Proposal: Addition of rooflight to front elevation, concrete drive changed to permeable concrete block paving (proposed as non-material amendments to 20/02155/F)

- 2.1. Addition of rooflight to front elevation, concrete drive changed to permeable concrete block paving (proposed as non-material amendments to 20/02155/F)

Application: 20/02155/F	Permitted	5 October 2020
--------------------------------	-----------	----------------

Proposed Front Elevation

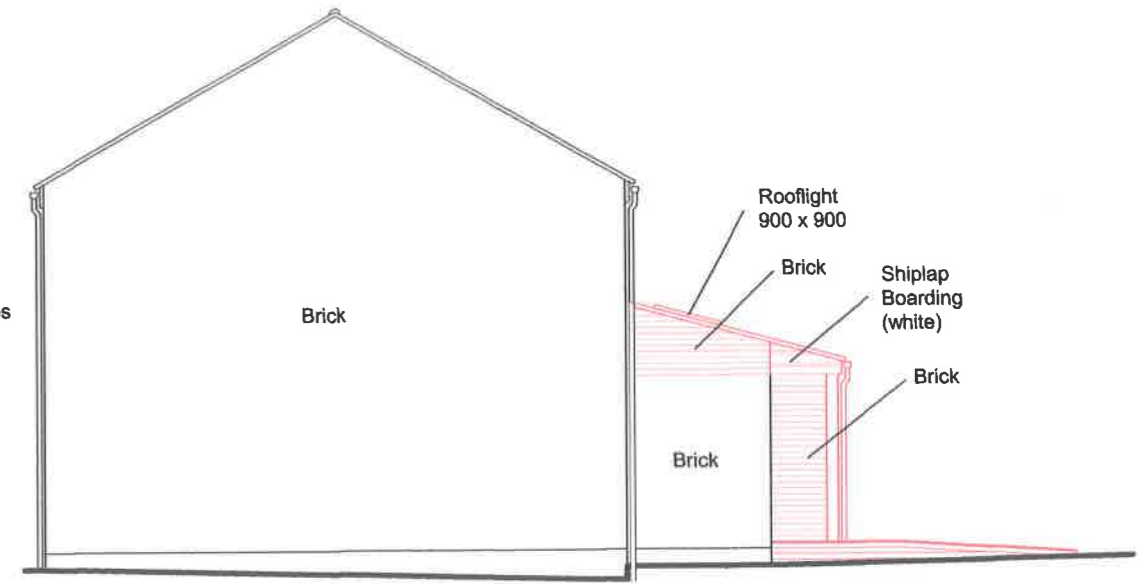
- 5.5. The proposed rooflight would be in the front facing roof slope of the extension. The rooflight would be less than 150mm from the roof plane, which would mean that it could be inserted in the roof slope under permitted development once the approved scheme was completed.

Proposed Ground Floor

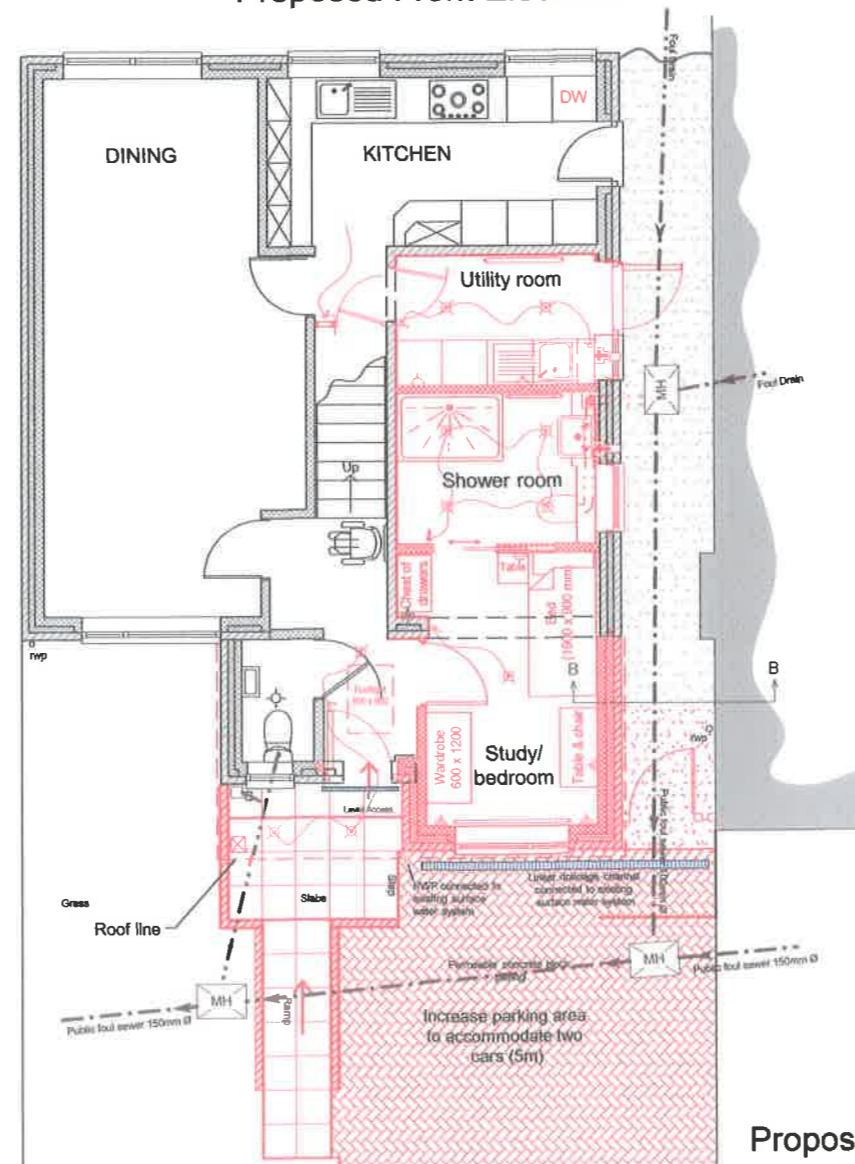
- 5.6. The proposed block paved driveway would be permeable and as such would also constitute permitted development.
- 5.7. The proposals do not conflict with any other conditions in the decision notice for 20/02155/F and given the permitted development fall-back it is considered that the proposals are non-material.
